From: Contact Centre (CRM) <contact@ribblevalley.gov.uk>
Sent: 20 March 2024 10:32
To: Planning
Subject: Planning Application Comments - 3/2024/0164 FS-Case-597854040

Planning Application Reference No.: 3/2024/0164

Address of Development: 11 Primrose Road

2 PROPOSED SITE PLAN

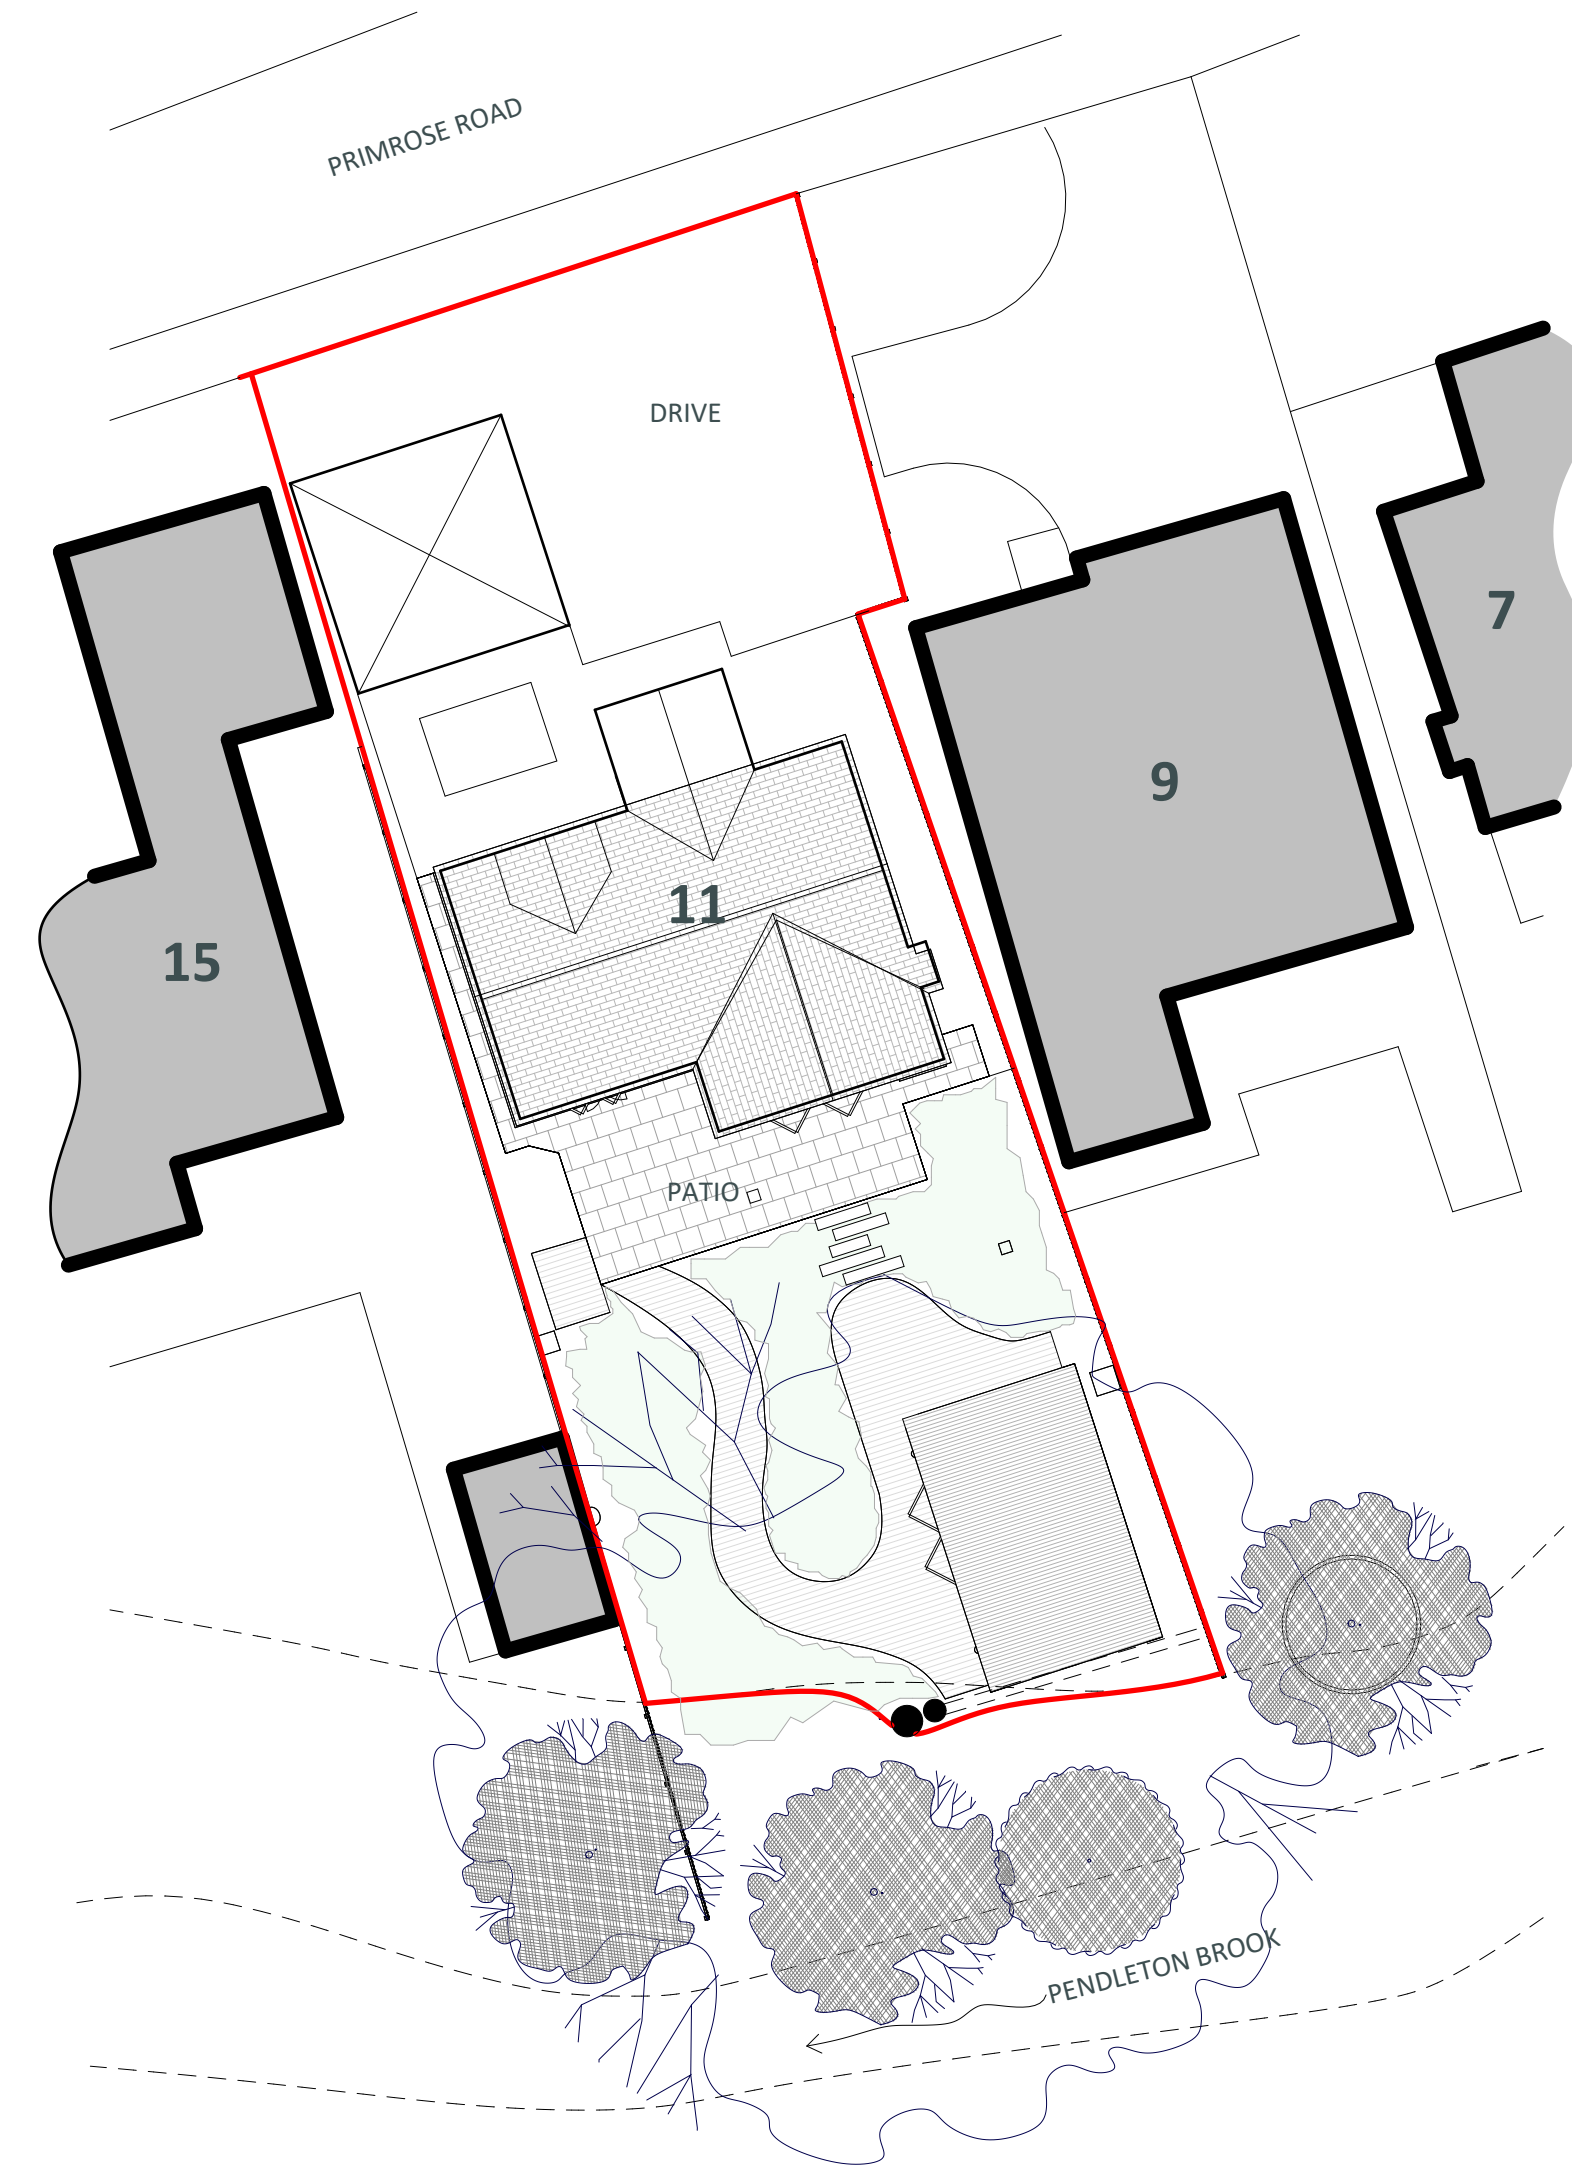
Comments: Please can you confirm if there is an intention to replace the fences on both sides of this property? If so are these fences just in the garden area or are they extended to running down the slope towards the brook as indicated in the visuals on the statement document.

Comments: objections to replacing fencing on [REDACTED]
[REDACTED] due to electric cabling running and electric points attached to the fence, also the fencing is recently painted to match the [REDACTED]
